City of Portland, Maine - Building or Use Permit Application
 389 Congress Street, 04101 Tel: (207) 874-8703, Fax: (207) 874-8716

Permit No: 05-1090	Issue Date:	CBL: 377 E002001
------------------------------	--------------------	----------------------------

Past Use: single family residence	Proposed Use: single family residence with garage rebuilt on existing foundation	Permit Fee: \$156.00	Cost of Work: \$15,000.00	CEO District: 5
Proposed Project Description: Rebuild garage on existing foundation at single family residence		FIRE DEPT: <input type="checkbox"/> Approved <input type="checkbox"/> Denied	INSPECTION: Use Group: Type	
		Signature:	Signature:	
PEDESTRIAN ACTIVITIES DISTRICT (P.A.D.)				
Action: <input type="checkbox"/> Approved <input type="checkbox"/> Approved w/Condition <input type="checkbox"/> Denied				
		Signature:	Date:

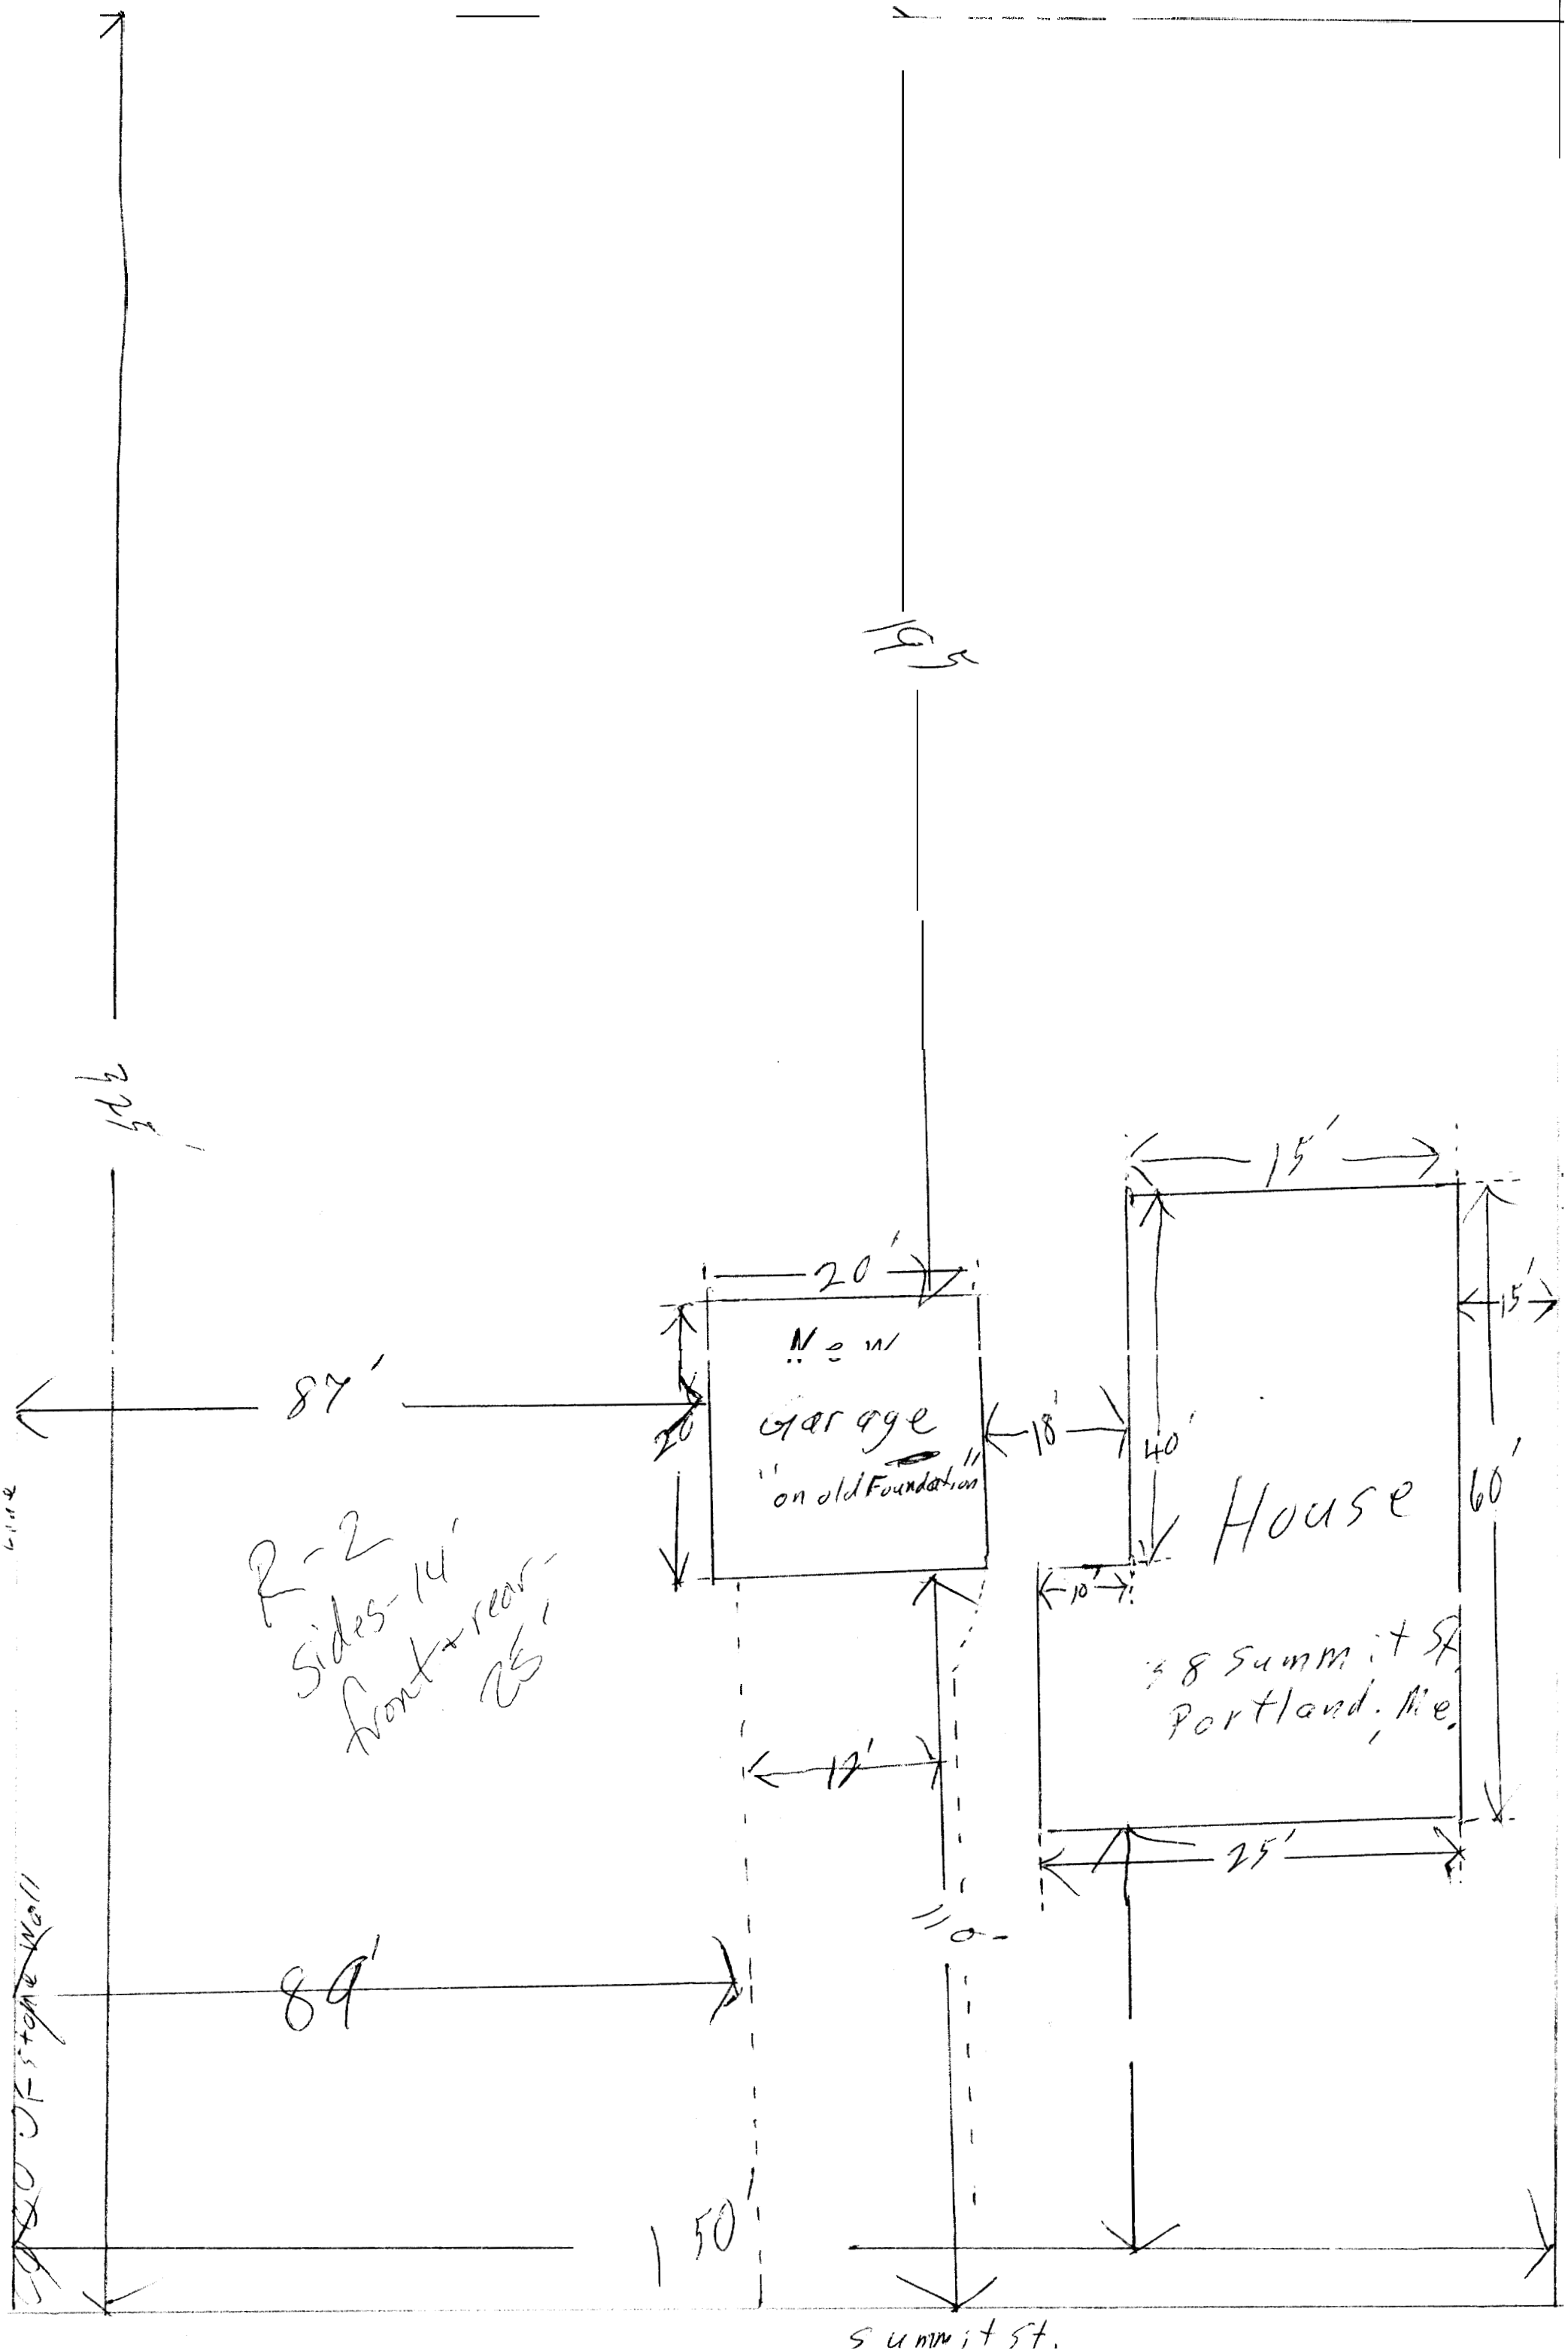
Comments:
8/24/05-tmm: need 2" x 8" rafters, need 2- 2" x 8" s header over garage doors, need fully labeled cross section - went over w/builder.
